**Re: Tramway Linear Park Phase I
Grading and Drainage Plan
Engineer's Stamp dated 2-24-10 (K22-D053)**

Re: Tramway Linear Park
K22/D053 (SEC# 109621)

Re: Tramway Linear Park Phase I Grading Plan
Engineer's Stamp dated 1-20-10 (K22/D053)

TITLE: TRAMWAY LINEAR PARK - PHASE I
GRADING PLAN

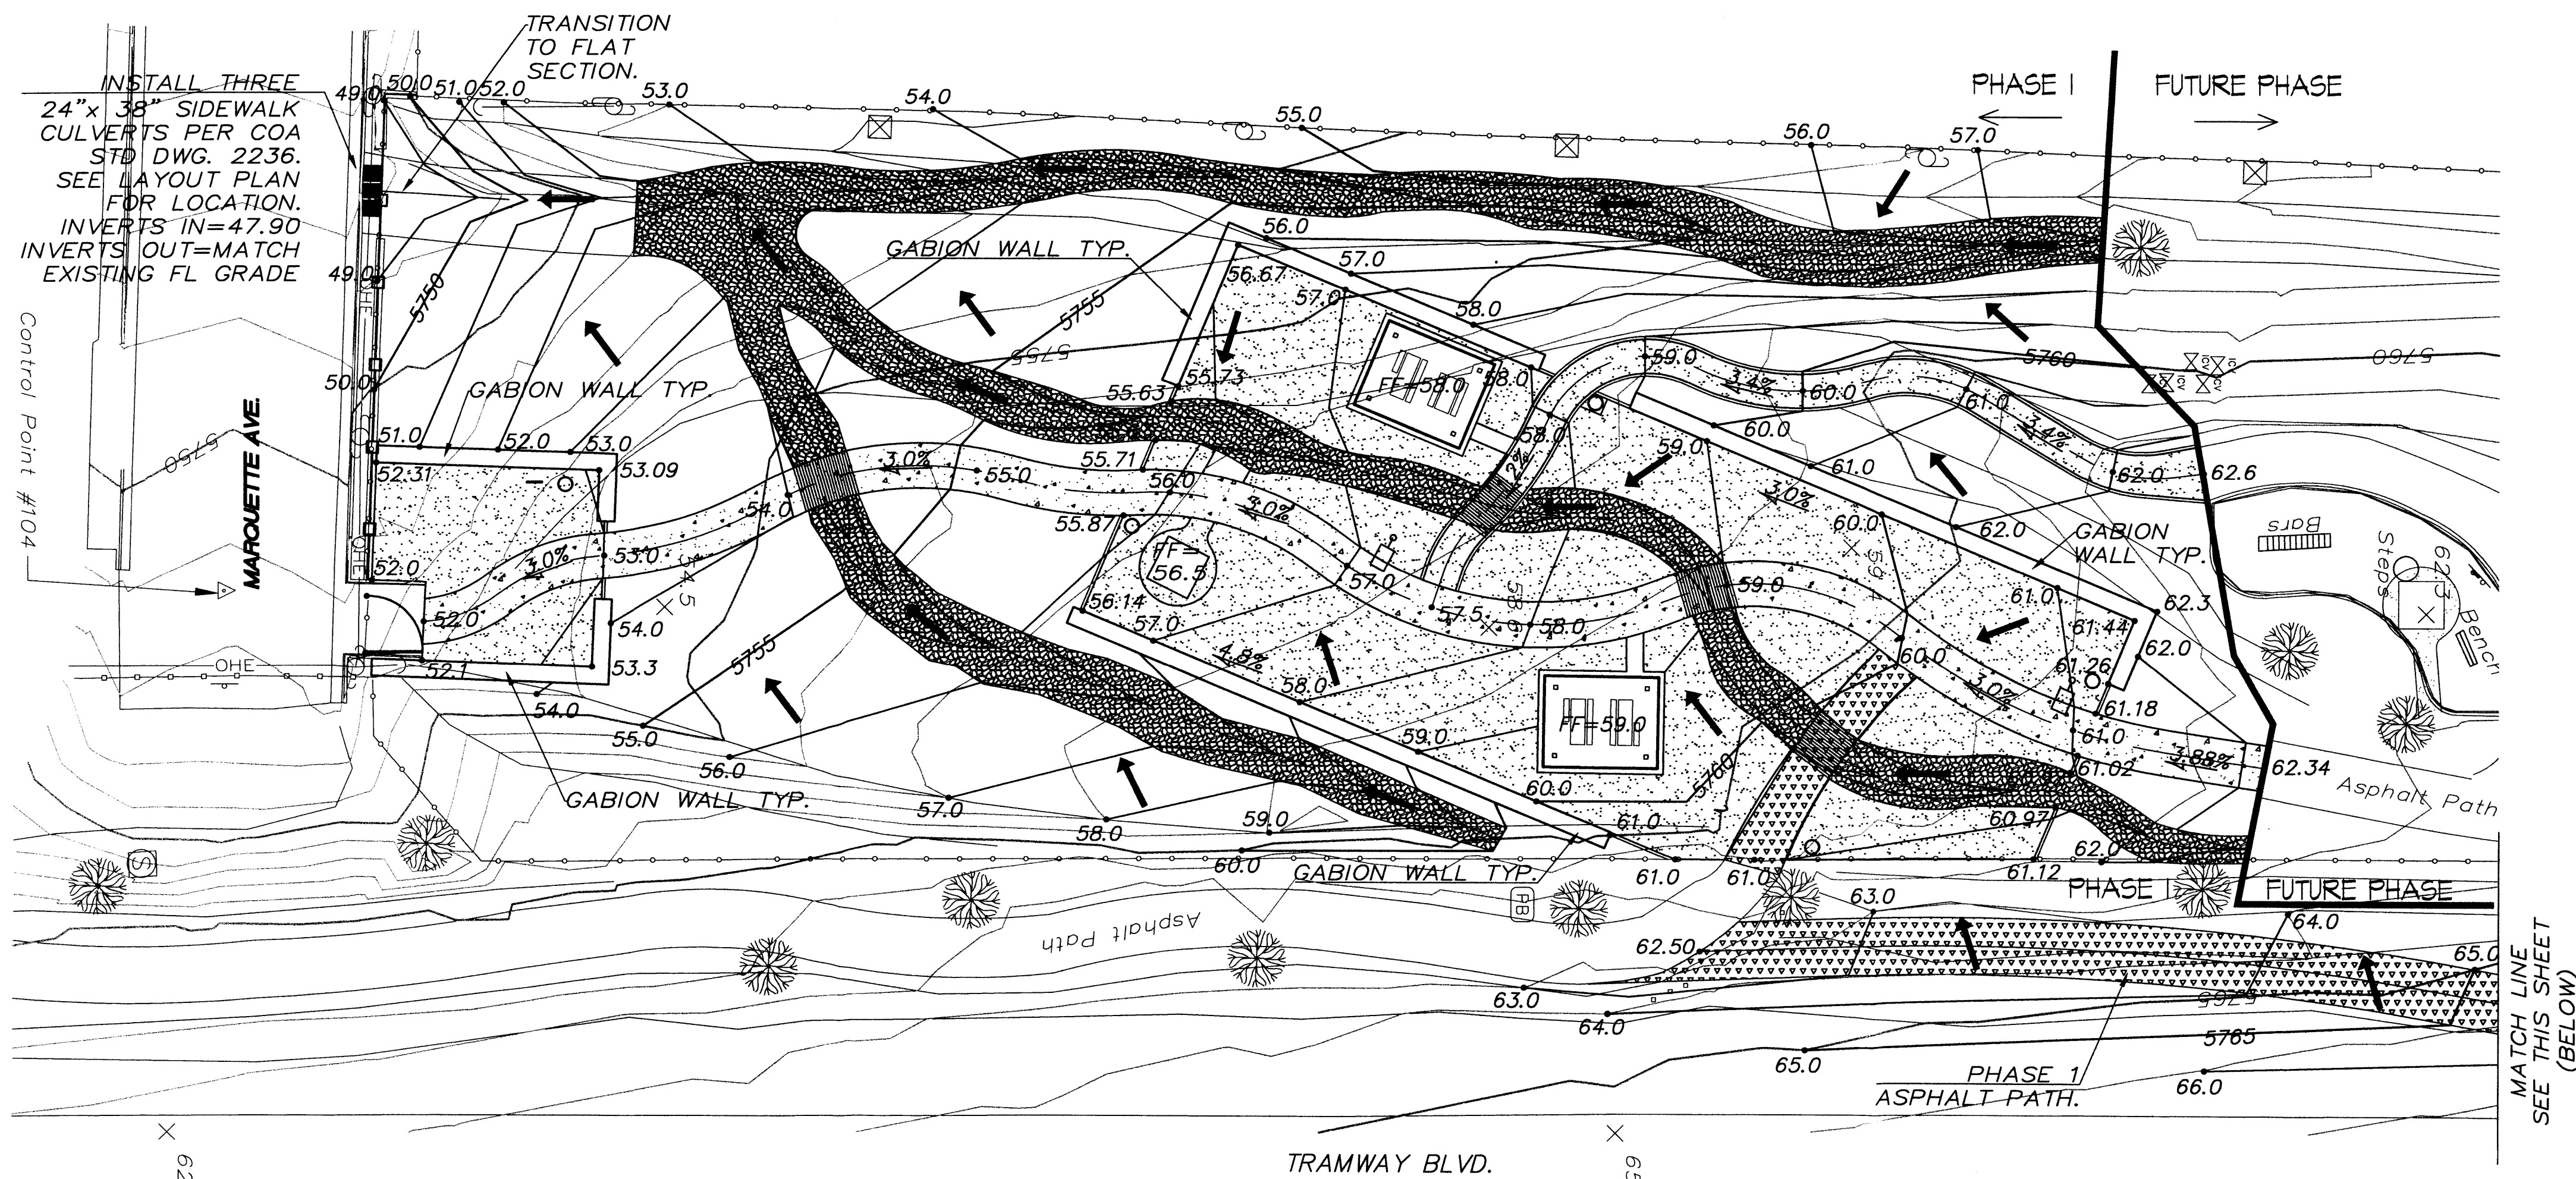
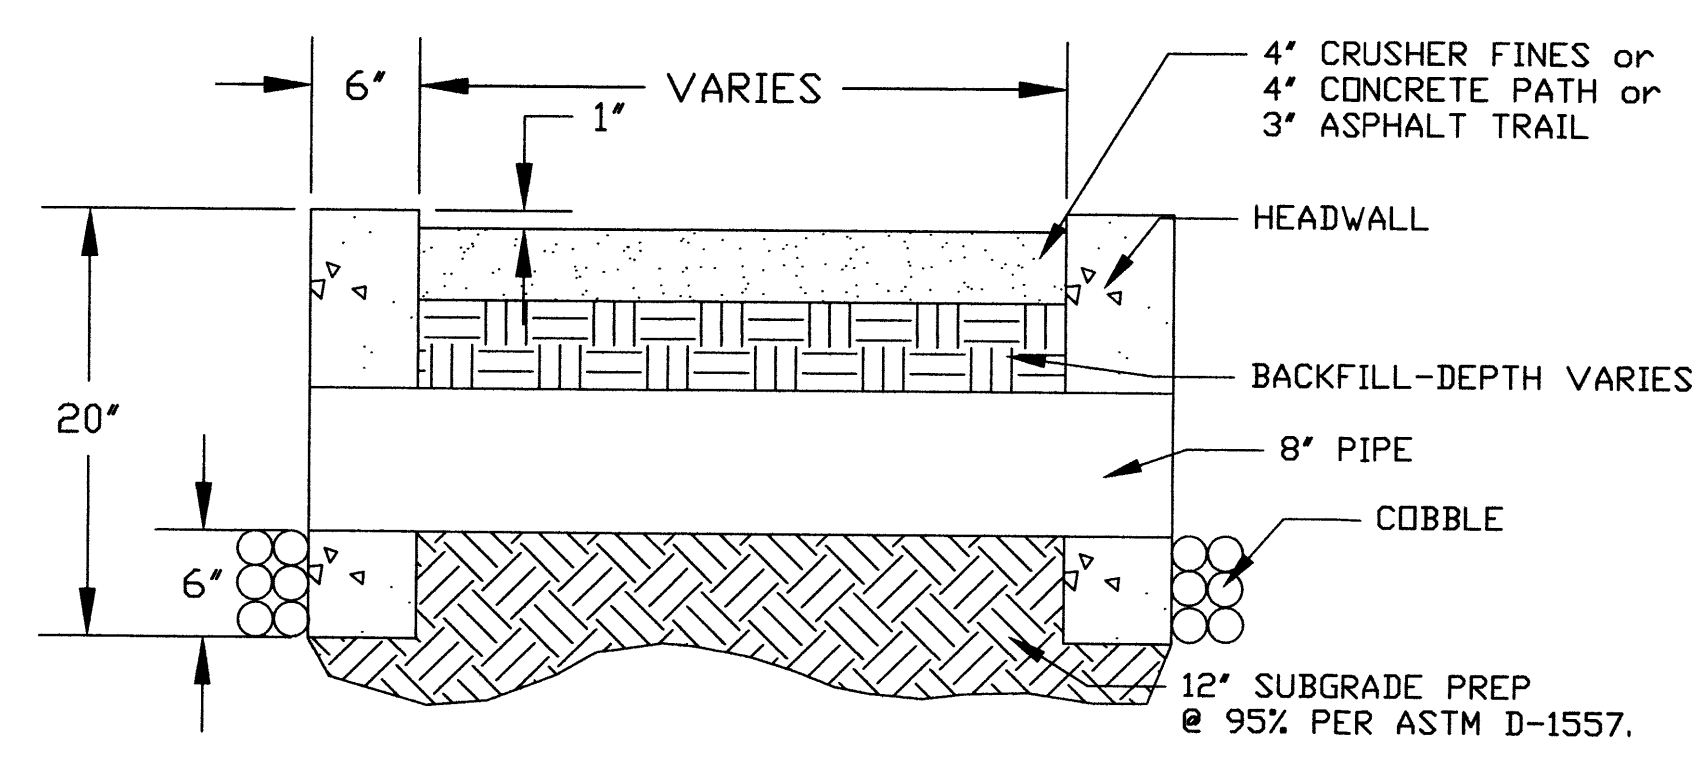
- 1) Build notes are needed for the sidewalk culverts, swales, etc.
- 2) Provide a cross section of the swales. Will they all be the same width and depth?

1. Coordinate points for the center of both the inlet and outlet ends of the three proposed sidewalk culverts have been added to the LAYOUT PLAN, sheet 11 of 13.
2. A Typical Swale Section has been added to the GRADING PLAN, sheet 9 of 13.
